From: [Downes, Scott G \(DFW\)](#)
To: [Kelly Bacon \(CD\)](#)
Subject: RE: SE-22-00002 Cape - Comments Response
Date: Friday, March 4, 2022 1:44:55 PM

From: Kelly Bacon (CD) <kelly.bacon.cd@co.kittitas.wa.us>
Sent: Friday, March 4, 2022 1:31 PM
To: Downes, Scott G (DFW) <Scott.Downes@dfw.wa.gov>
Subject: SE-22-00002 Cape - Comments Response

The applicant for SEPA application SE-22-00002 Cape provided the following response to WDFW comments:

Parcel #19162 Driveway Improvement Extents

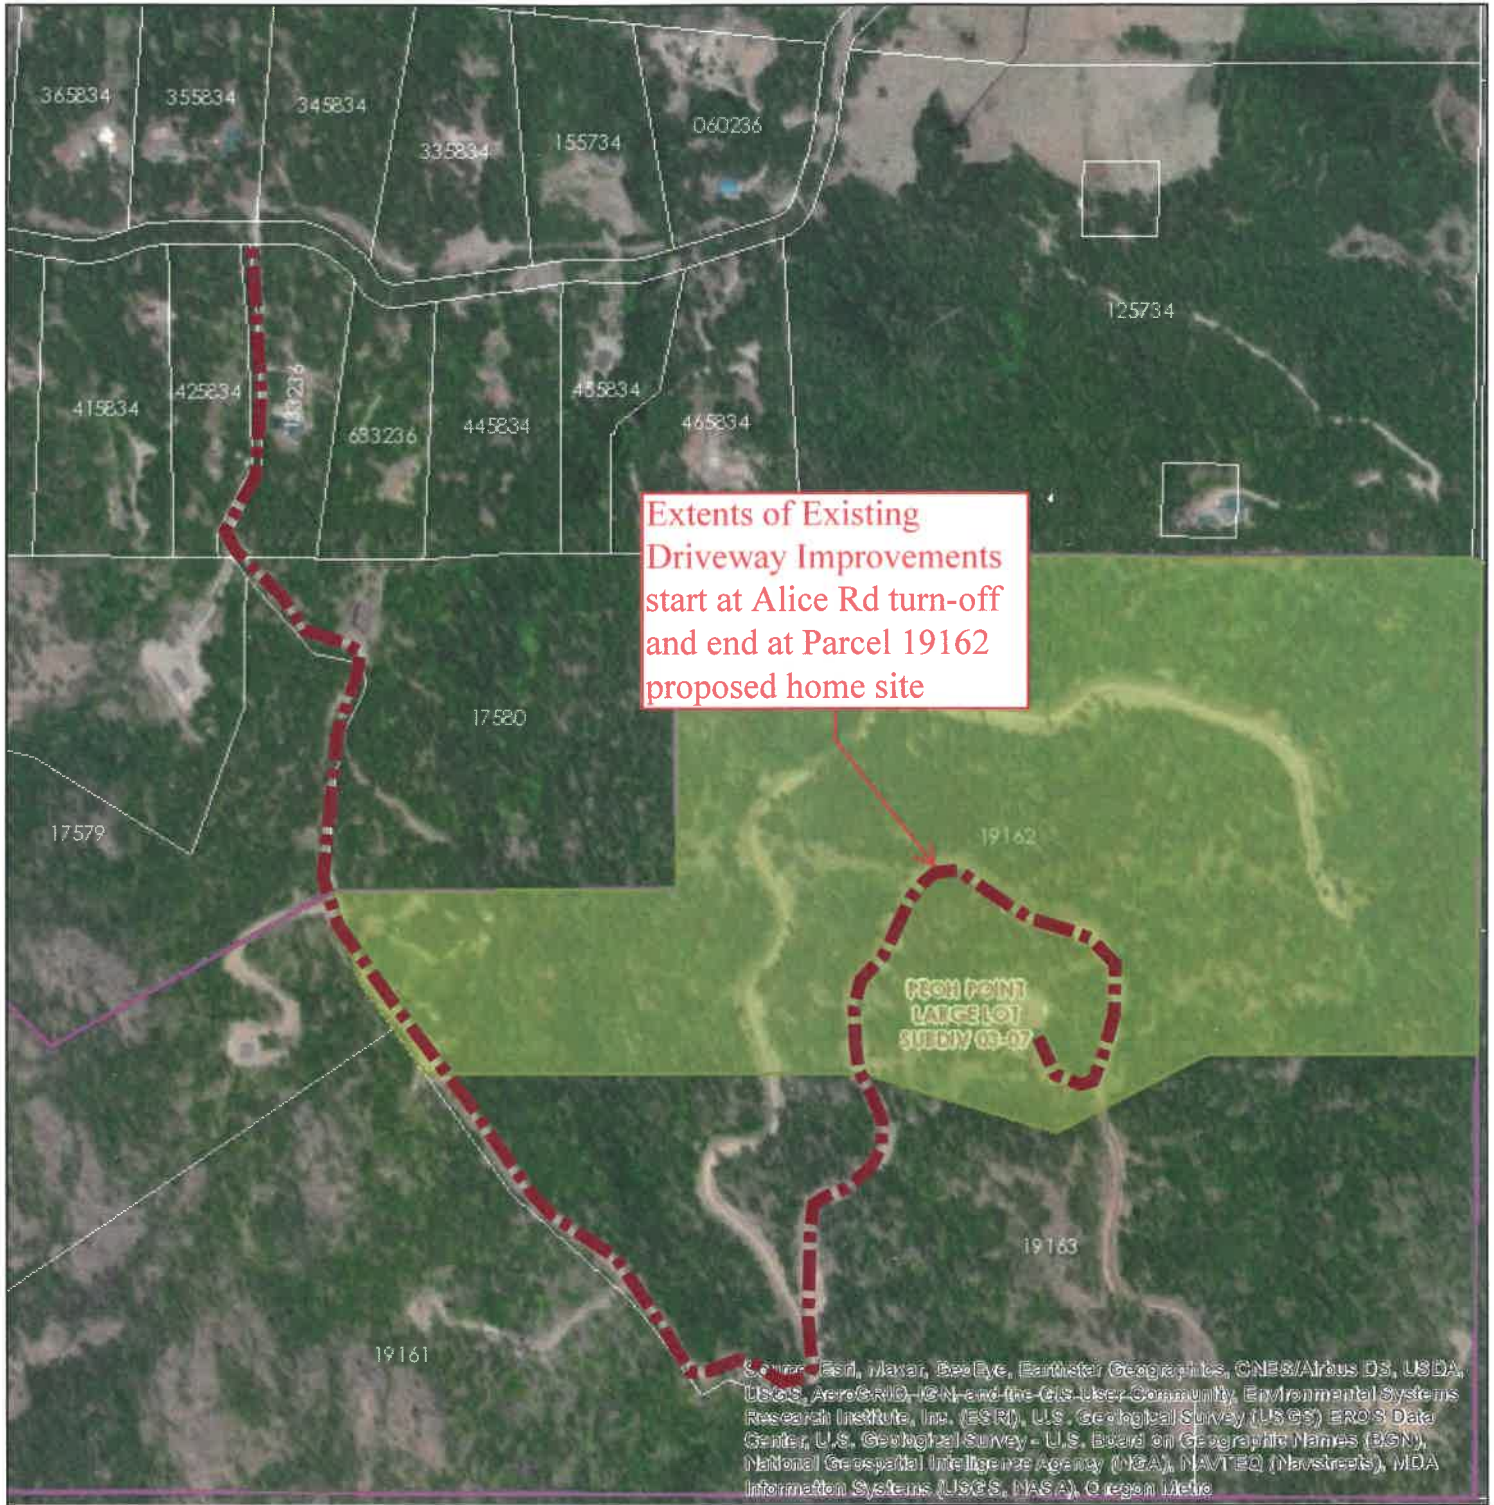
Thank you for this. Yes, we need to setup a meeting (I think I saw DNR was requesting as well). If the hydraulics are ok, they could be extended but if they are undersized, the entire culvert may need to be upsized. A site visit would help to determine that. If they could setup a meeting as soon as the snow comes off that would help to move this along.

No change in size, grade, alignment, or material are proposed for any culvert. Culverts will

be

extended as needed per WSDOT Hydraulics Manual Section 3-3.1.6 and we understand WDFW would like to examine the culverts. We will ensure that occurs.
